[illegible]

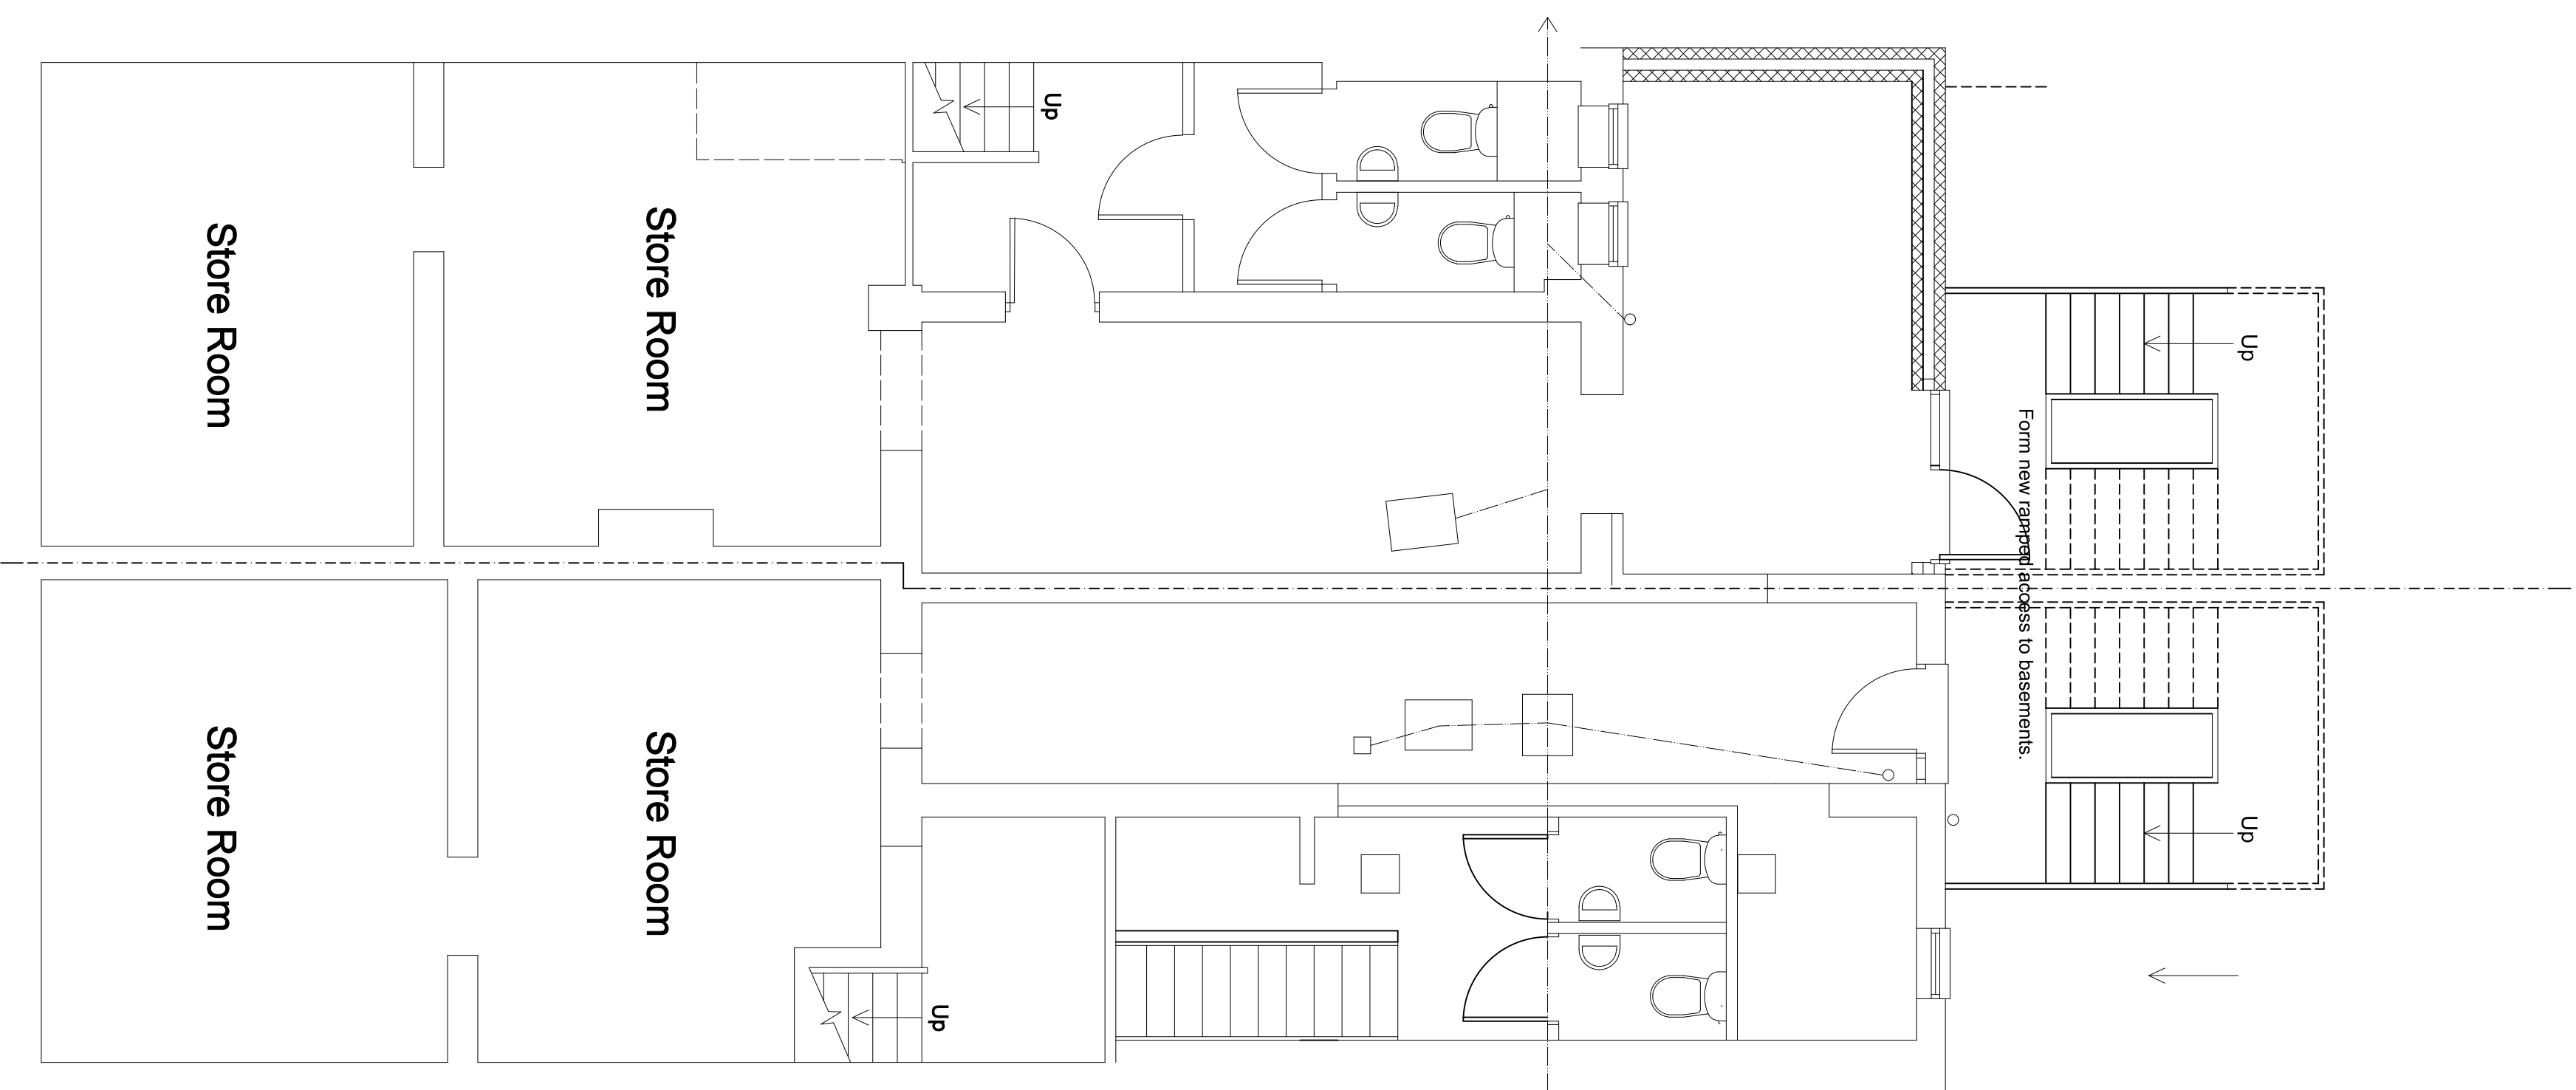
‘Regarding the ground floor retail premises proposals, it was observed that alterations to the Pier Road frontage would see the floor level raised by 50cm. The Plans however lacked clarity regarding this change or any detail on

provisions that would allow accessibility for those with impaired mobility. Similarly, there appeared to be no disabled toilet provision. Members considered the lack of these facilities went against the Arun's Local Plan strategic objectives for design (Section 13) and the emerging Design Guide which sought to promote development providing "opportunities for ease of movement for pedestrians" and buildings that were of a "good design which will contribute positively to making places better for people".

Lack of access and provision for disabled customers would be contrary to policy D DM1(5) and in its current form the application may well be recommended for refusal on this basis. I would therefore appreciate your comments/clarification, within the next 10 days, in response to the issues raised.

I attach elevations with pavement level marked at the same level as door threshold-it is now not the intention to raise the floor level as was proposed in the previous planning application LU/414/17/PL.

As regards the provision of toilets for disabled customers, I would point out that the River Breeze restaurant has operated with toilets on the lower ground floor for many years, and as the total seating for the two restaurants will be less than for the existing restaurant, it is felt that there is no worsening of a situation which it is conceded, is not ideal.

The problem faced by the client is simply that the installation of toilets fully compliant with Part M of the Building Regulations, with ventilated lobbies, at the same level as the restaurant seating, would take up so much floor space as to make the proposals unviable. As the retention of retail units is being encouraged, it is hoped that the Council will be sympathetic.
